Application number: 2023/91250	
What is the application for?:	Prior notification for proposed 15m 5G telecoms installation: H3G street pole an
Address of the site or building:	Owl Lane, Shawcross, Dewsbury, WF12 7RQ
Postcode:	RG2 6GF

Title: **265 PROPOSED SITE ELEVATION**

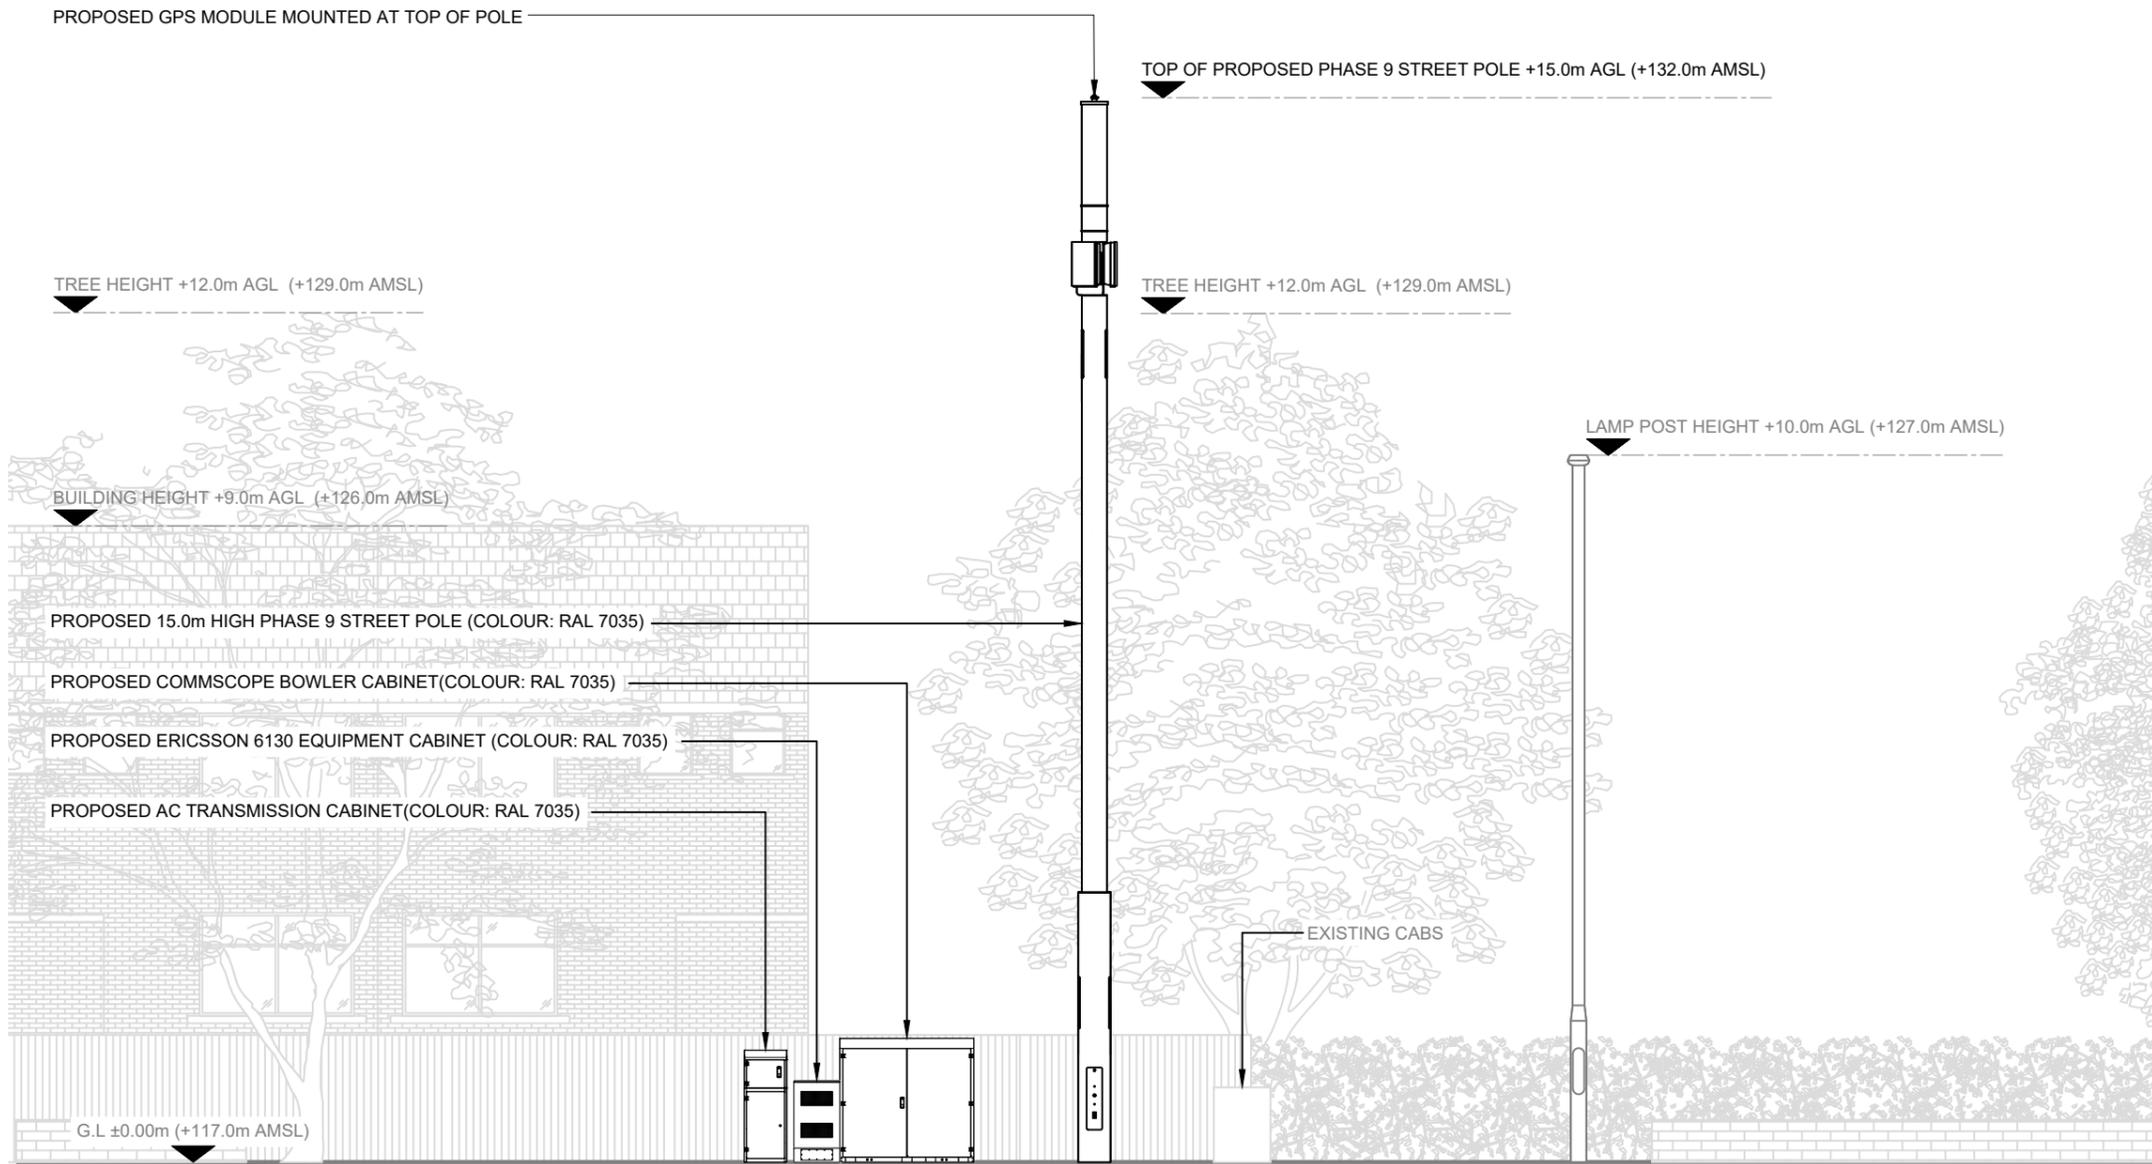
Type of comment: An objection	
Do you wish your comments to be published on the website anonymously?	No
<p>This was rejected earlier this year and there is nothing different about the new notification.</p> <p>It is an eyesore and will look totally out of character at the side of houses and 2 lovely big trees with nesting birds in. There are much more convenient areas for it, such as at the lights near the petrol station and macdonalds. There is already spare land there. And it contravenes still chapters 10 and 12 of kirklees policy LP24. Do not let this go ahead.</p>
